Final Report of Special Inspections

Project: *Addition and Renovation*

Location: *503 Woodfords Street, Portland, ME*

4 ROOF FRAMING PLAN
1/4" = 1'-0"
N

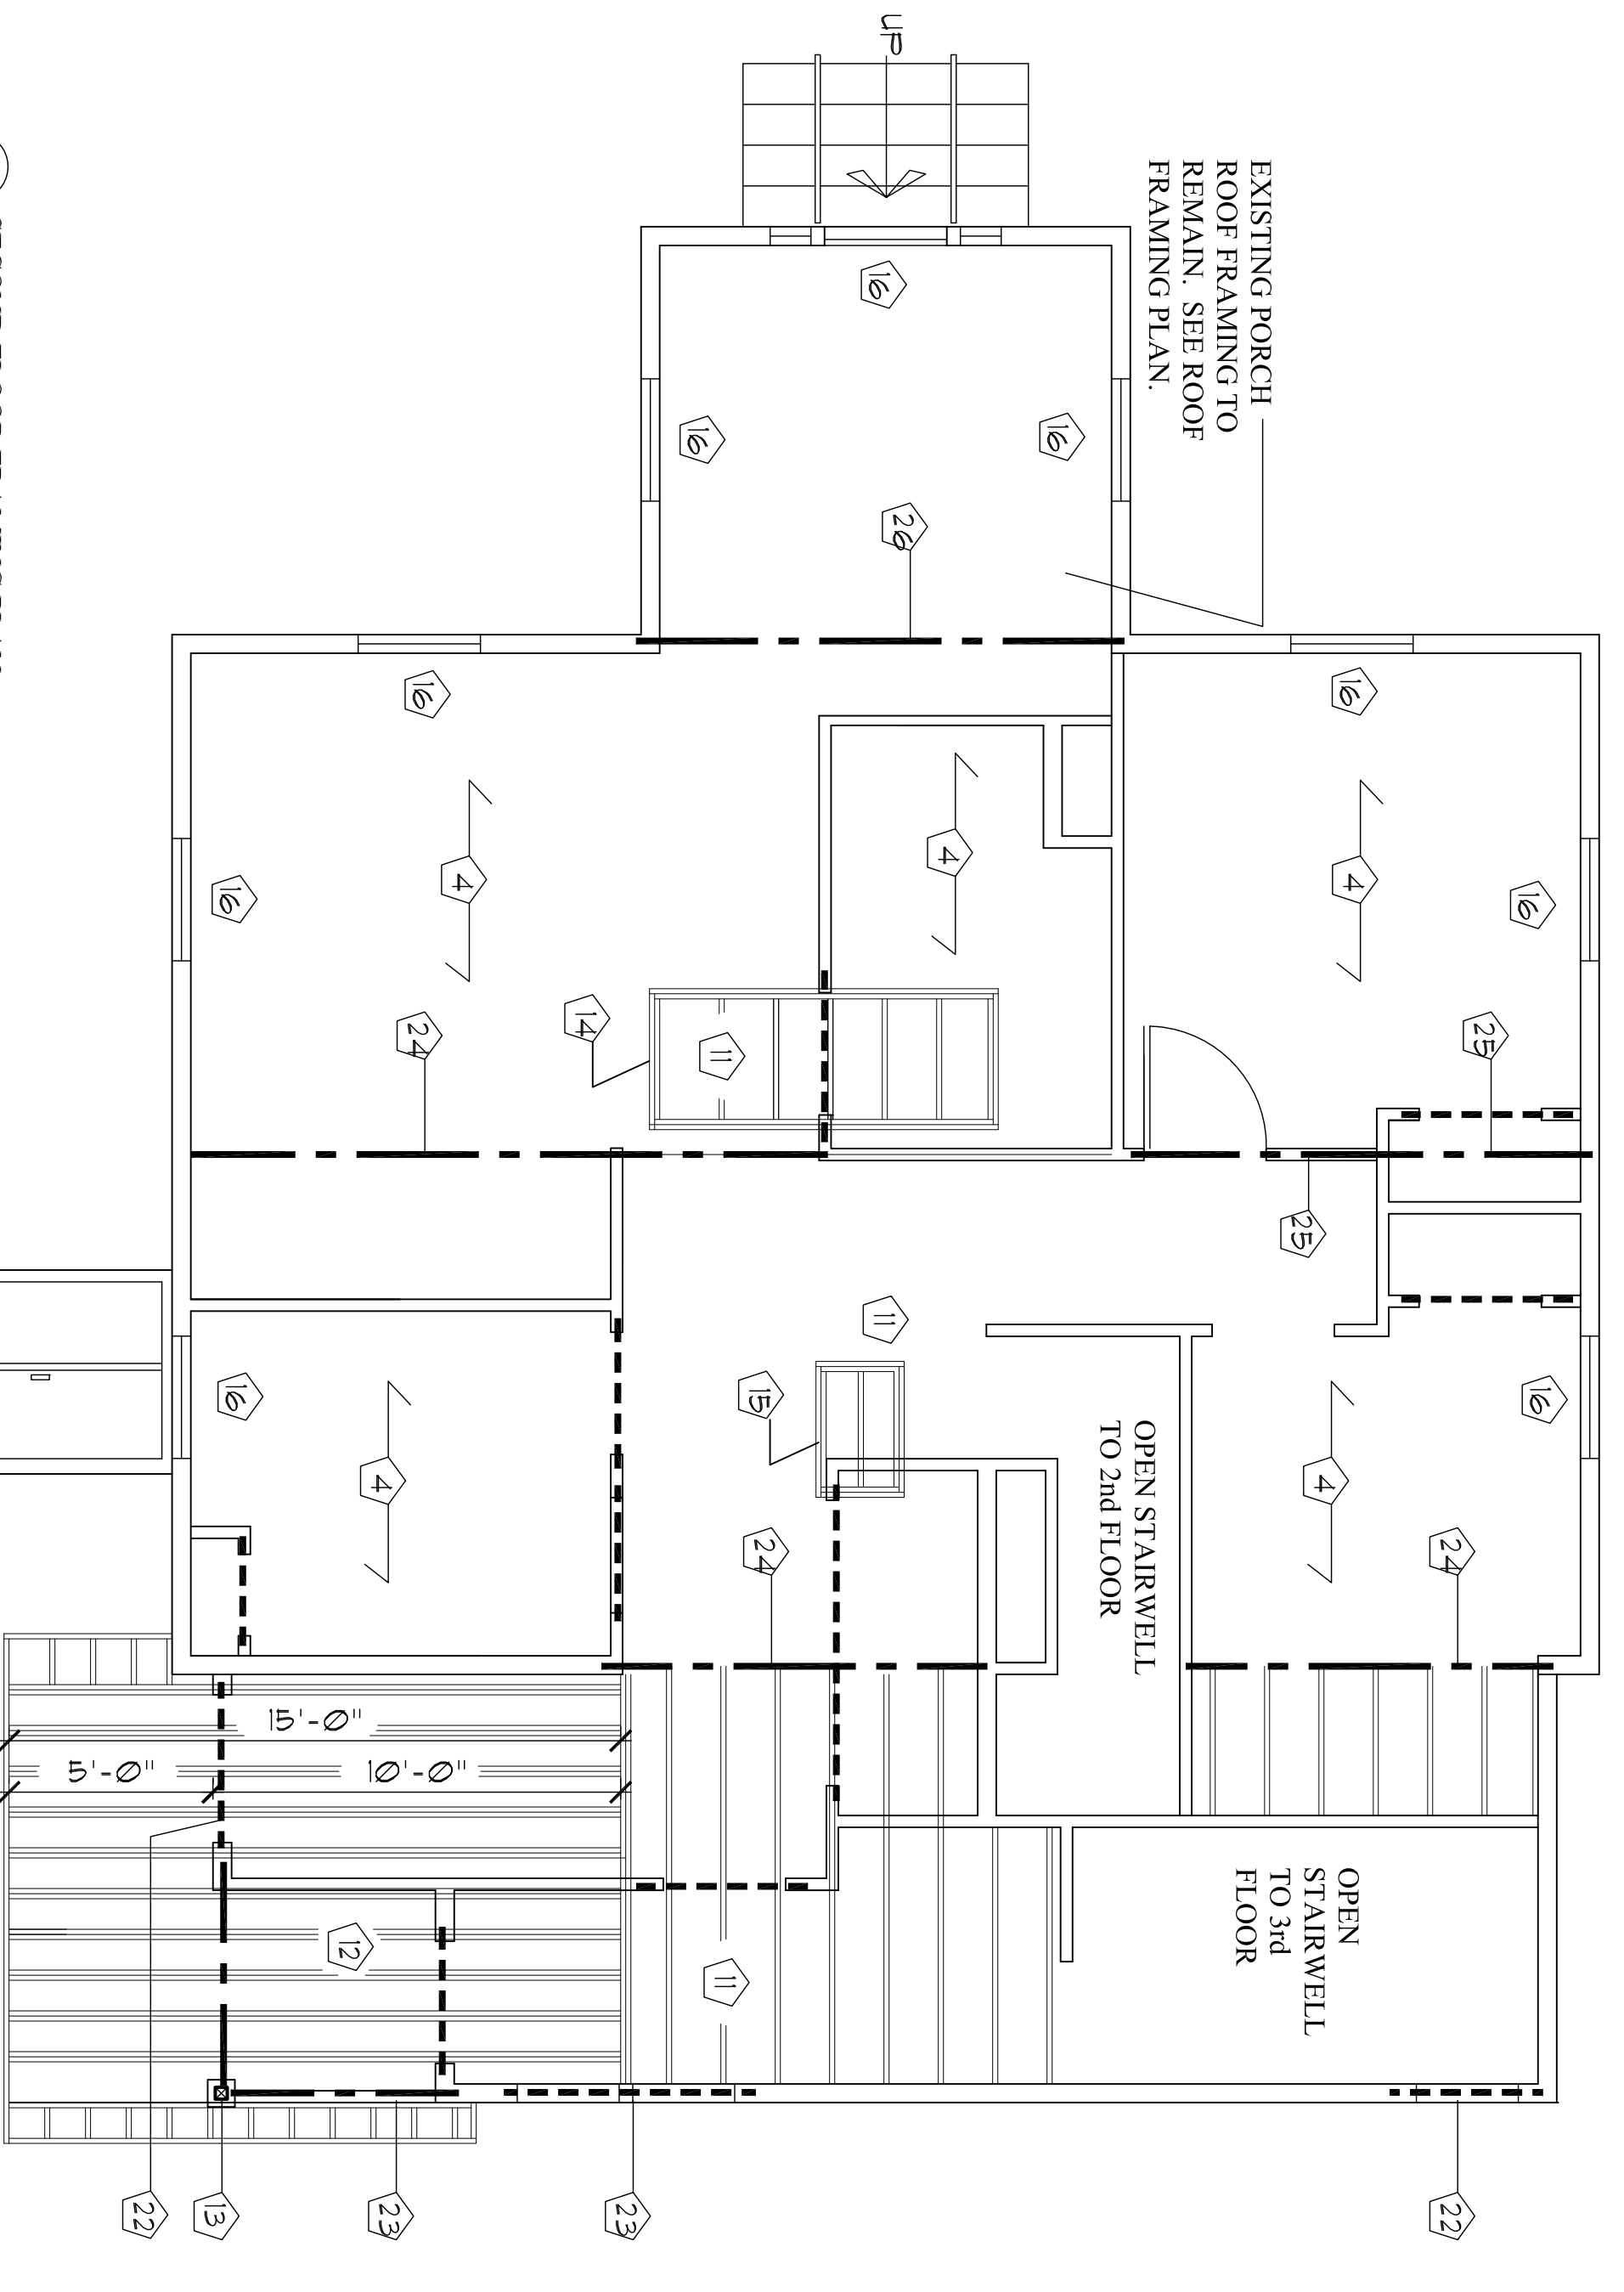
The east and west edges of the second floor dormers are supported by walls that are to be removed. There is a single 2x6 rafter above both of the existing walls. Both of these rafters must be reinforced with (2)1 $\frac{3}{4}$ "x5 $\frac{1}{2}$ " LVLs.

2 SECOND FLOOR FRAMING PLAN
1/4" = 1'-0"
N

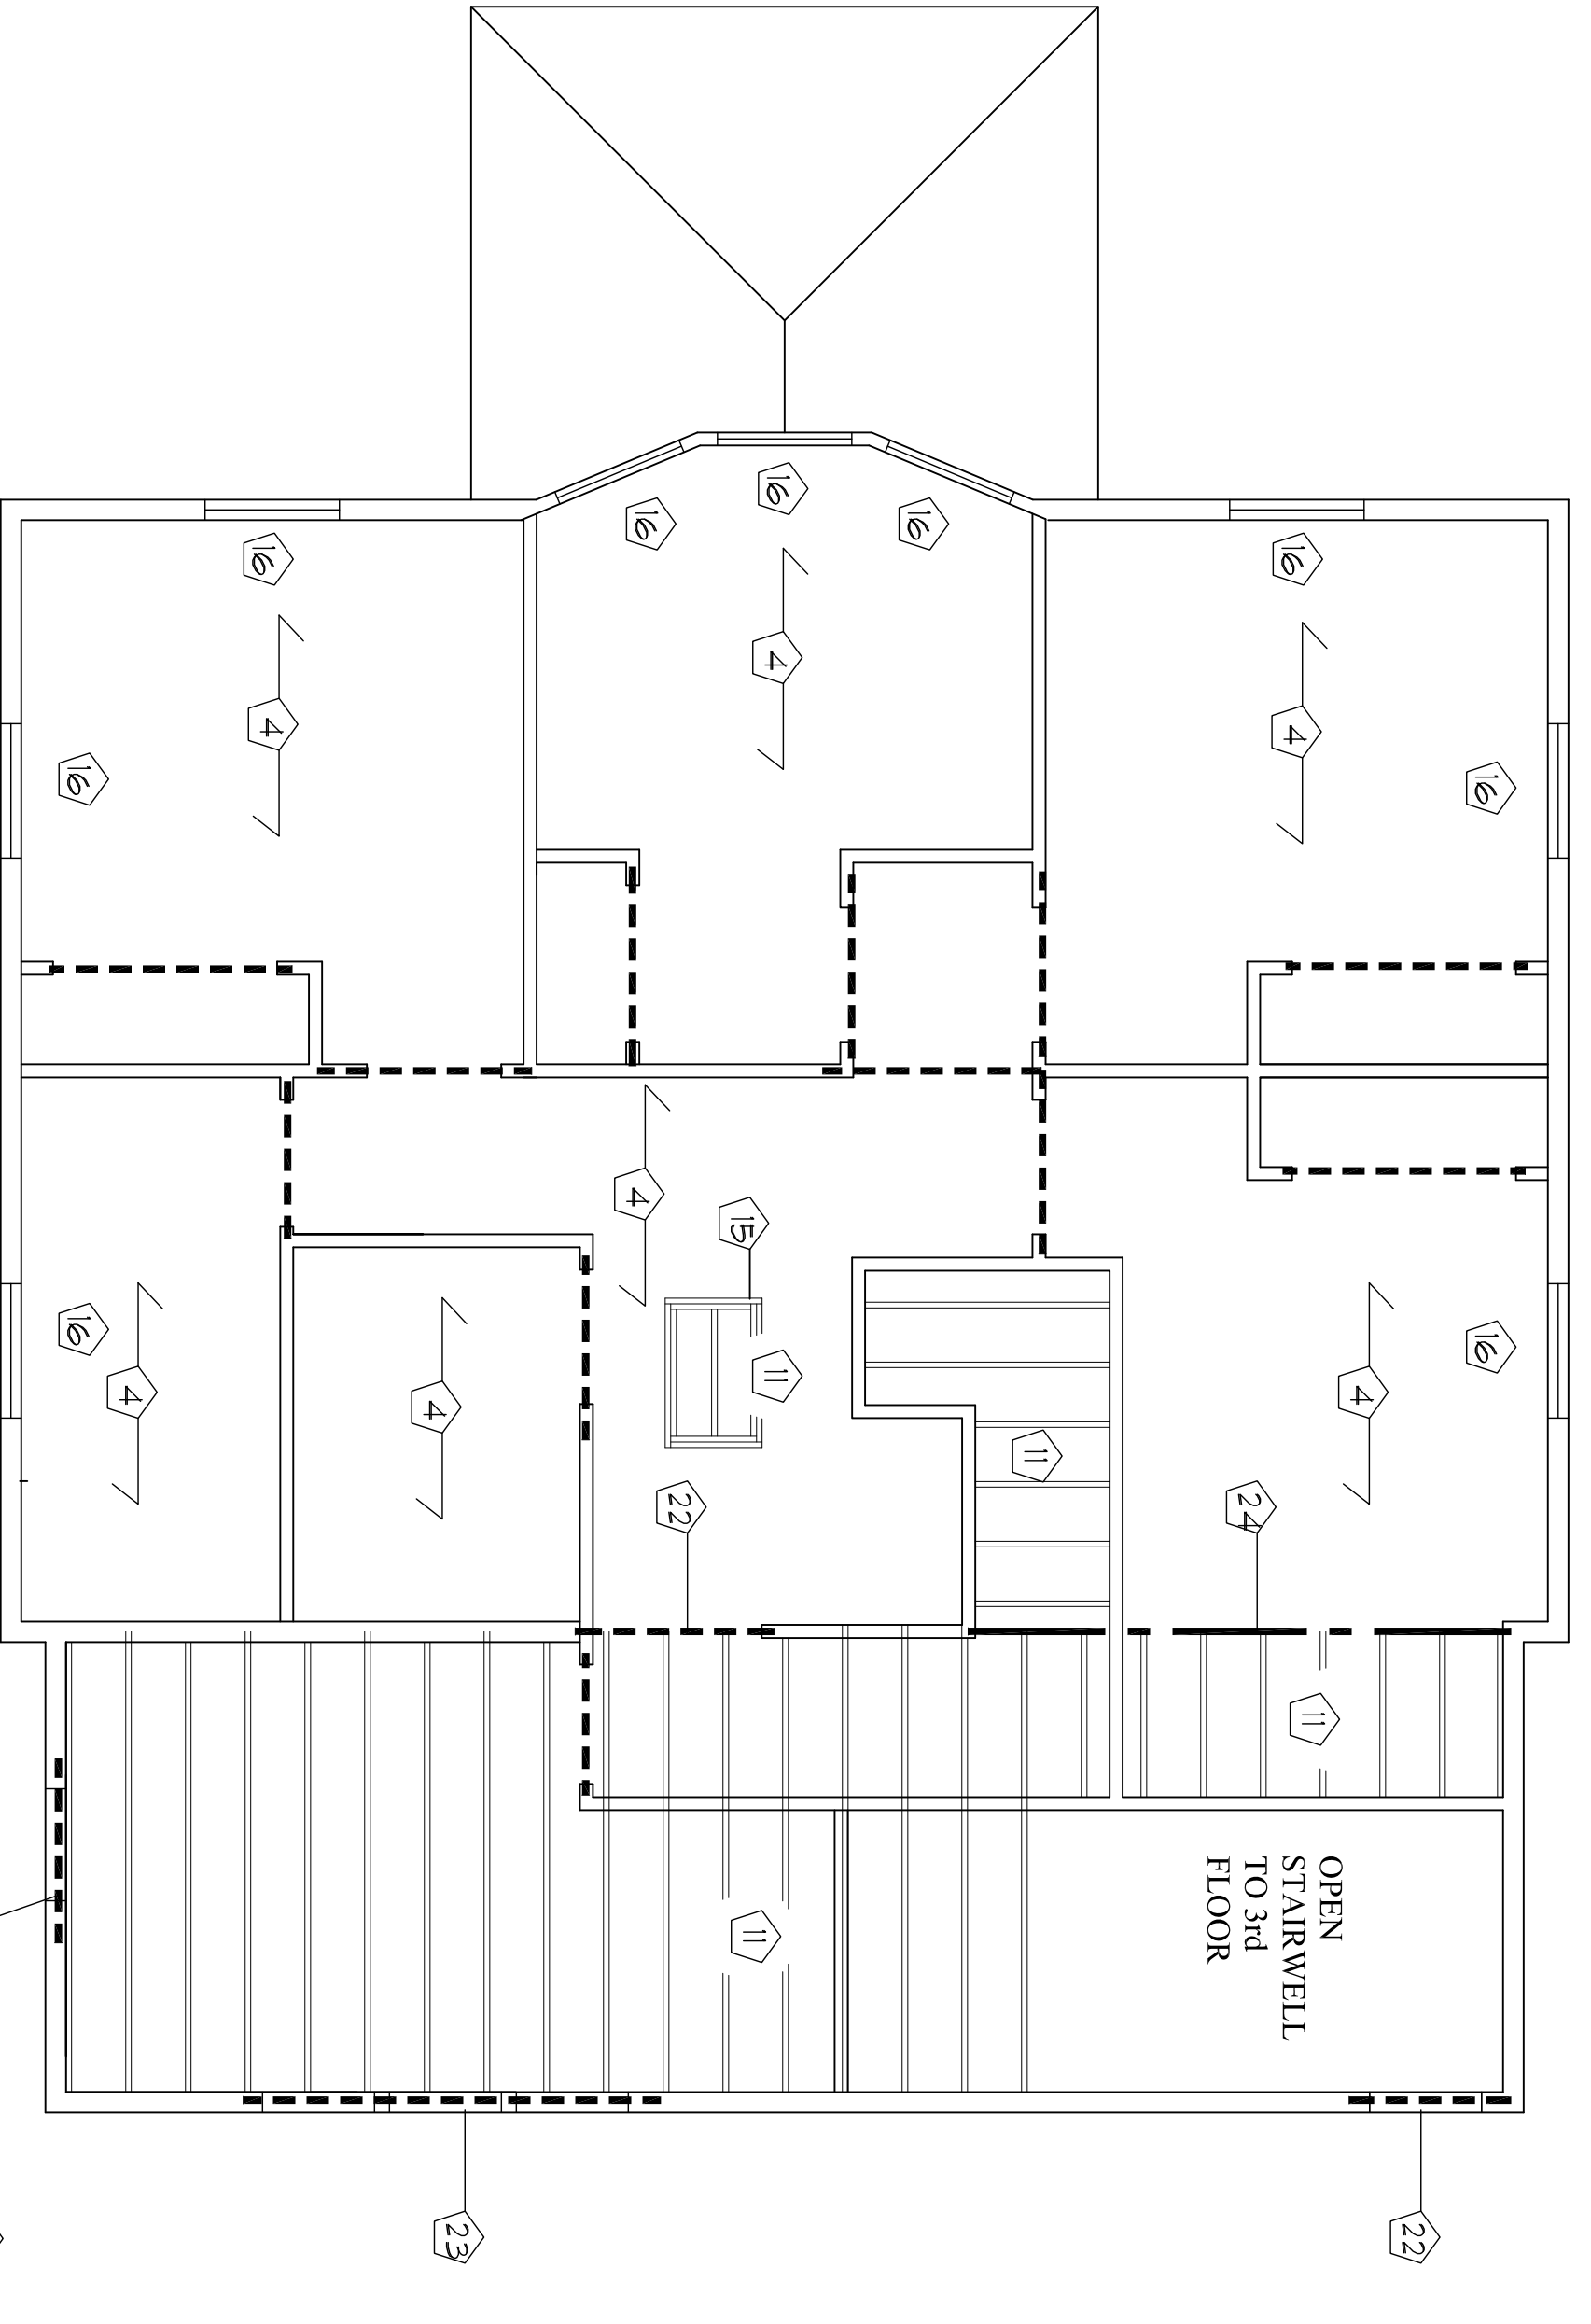
Second floor joists at both ends of the existing interior stair opening must be reinforced with (2) 2x8. Fasten the reinforcement joist to the existing joist as noted above.

The existing (3)2x10 second floor beam east of the existing interior stair is acceptable. A new beam in that location is not required.

The new (3)1 $\frac{3}{4}$ "x11 $\frac{1}{4}$ " LVL scheduled to be installed at the second floor in the south exterior wall must be shifted south to align with the south face of the exterior wall above.
